SOUTH HOLLAND DISTRICT COUNCIL

To: Planning Committee - 06 March 2024

Purpose: To consider Planning Application H23-0534-23

Description: Erection of 37 dwellings including road layout, scale, appearance and landscaping - outline approval H23-0827-22

Figure 3-4 Post Development Habitats

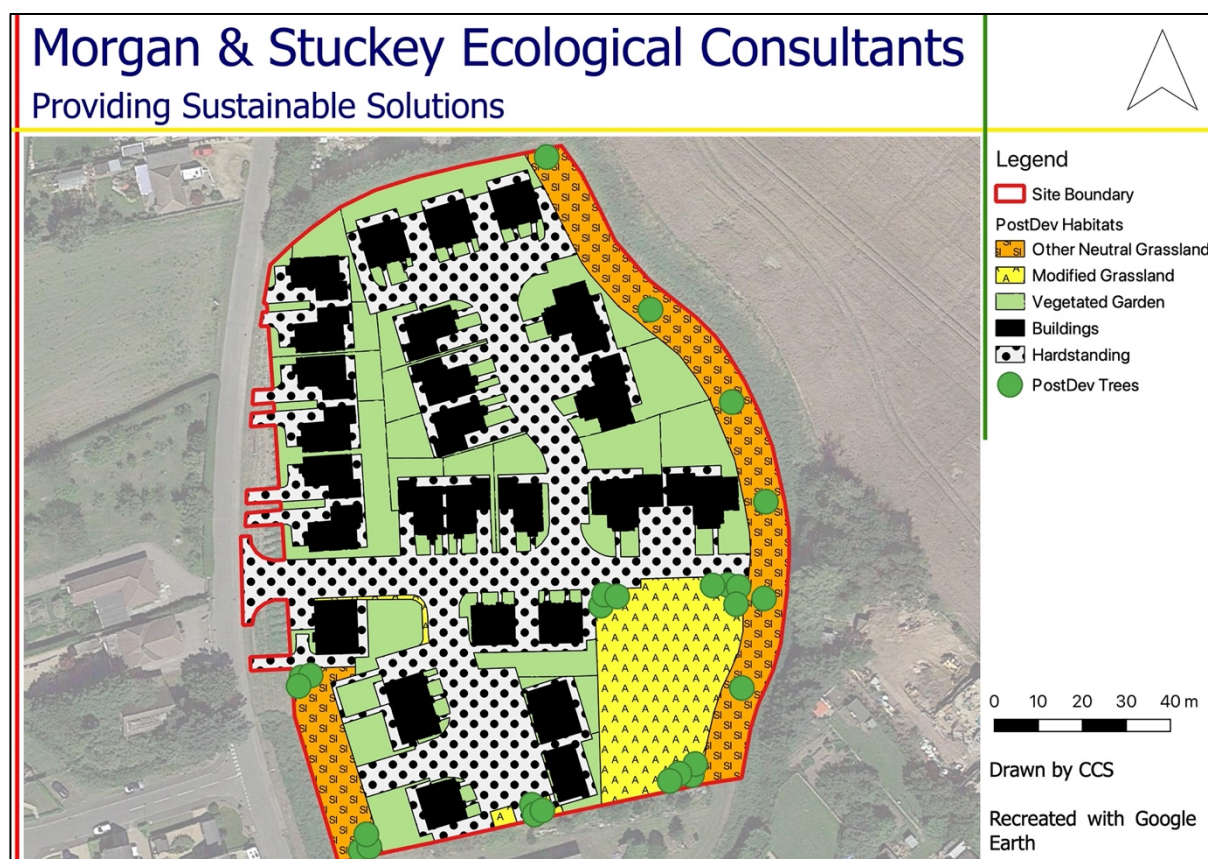
- 6.25 While the recommendations made in Section 6 of the Biological Impact Assessment document outline some appropriate management techniques, these need to be applied to a 30-year period. The 30-year management and monitoring plan needs to include who will be the responsible party for management, how the gains in biodiversity will be secured in perpetuity and be reviewed and updated over the course of the plan. The LPA should ensure that the plan is implemented and enforced.

- 6.43 **Consultation Responses - Responses Following Additional Habitat Management Plan**
- 6.44 Lincs Wildlife Trust
- 6.45 The HMMP looks acceptable and I am happy for the Holding Objection to be lifted.

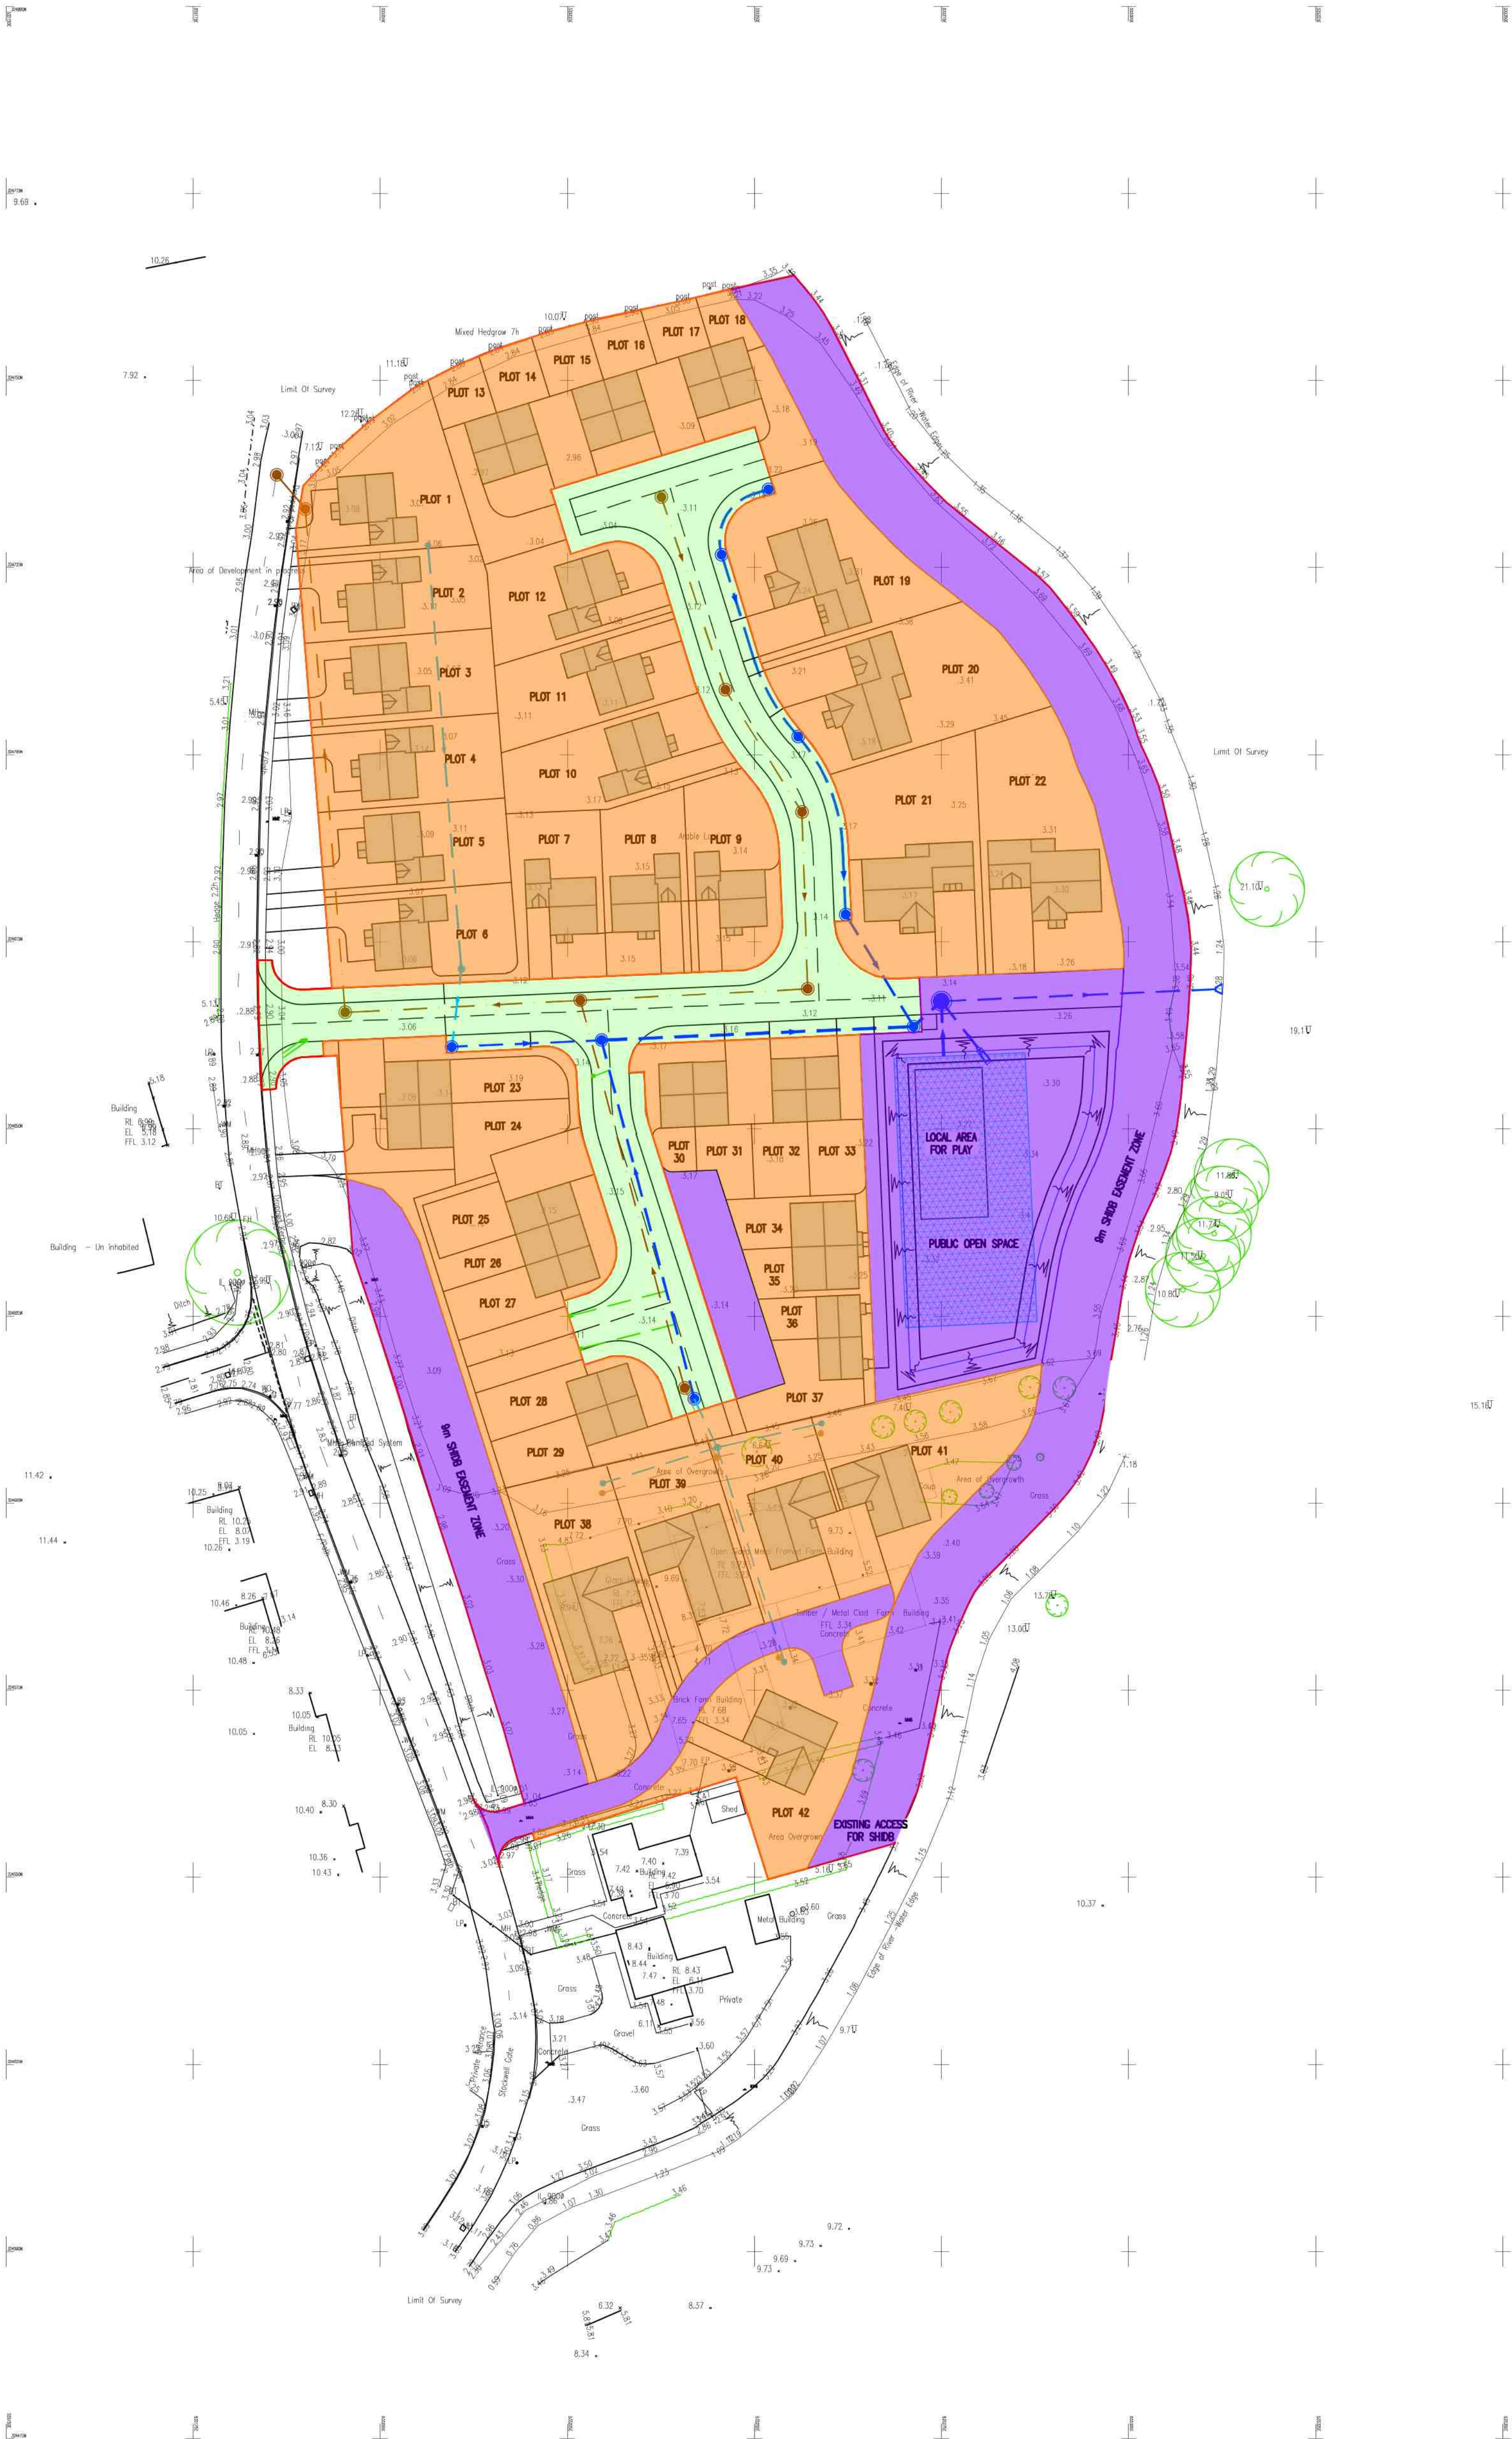
- 6.36 Lincolnshire County Council Highways/SuDS
- 6.37 The amendments do not include the roadside filter drains that were shown on the Approved Plans of the Outline Consent.

- 6.38 No additional drainage information has been submitted with this Reserved Matters Application so it is presumed that the Applicant is expecting to rely on the drainage strategy approved under the Outline Consent H23-0827-22. If so, then I am not able to clear this Reserved Matters Application with footways where there are supposed to be filter drains.

- 6.46 **Consultation Responses - Responses following Amendment 2**
- 6.47 Lincolnshire County Council Highways/SuDS
- 6.48 No Objections: The submitted highway and surface water drainage system detail, on the amended Site Block Plan numbered 4162/100/P3, dated 4.10.23 for this Reserved Matters Application, correspond with those of the development Consented under reference H23-0827-22.
